Consultation Response from KC, Trees
2025/91370 Land at, Gynn Lane, Honley, Holmfirth, HD9 6LF
REVISED AND ADDITIONAL INFORMATION RECEIVED: Demolition of existing dwelling and erection of 50 dwellings with associated access, infrastructure and associated works
Date Responded: 06/03/2026 Responding Officer: JD Responding Ref: 01/96

CULVERT LOCATION PLAN SCALE 1:200

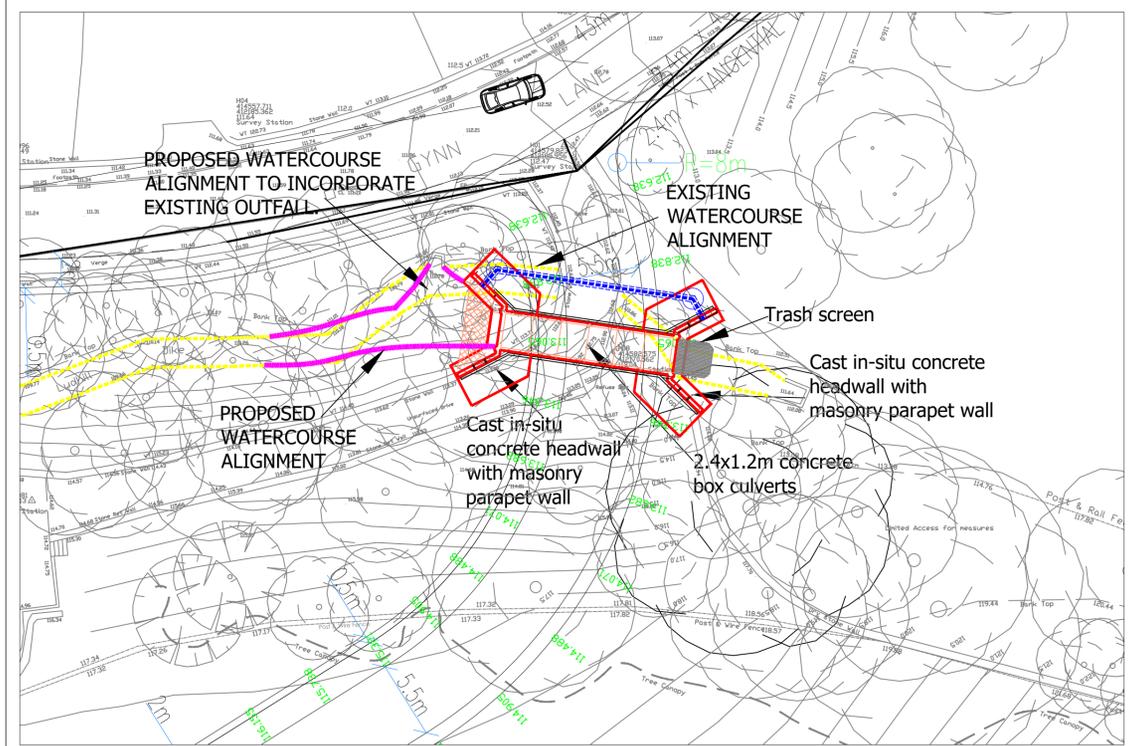
The newly proposed culvert appears to require further tree removal, this needs to be represented in an updated Arboricultural Impact Assessment showing the location and impact of said culvert.

There is a holding objection until a revised Arboricultural Impact Assessment is submitted showing the exact impact the culvert will have on the adjacent TPO'd trees.
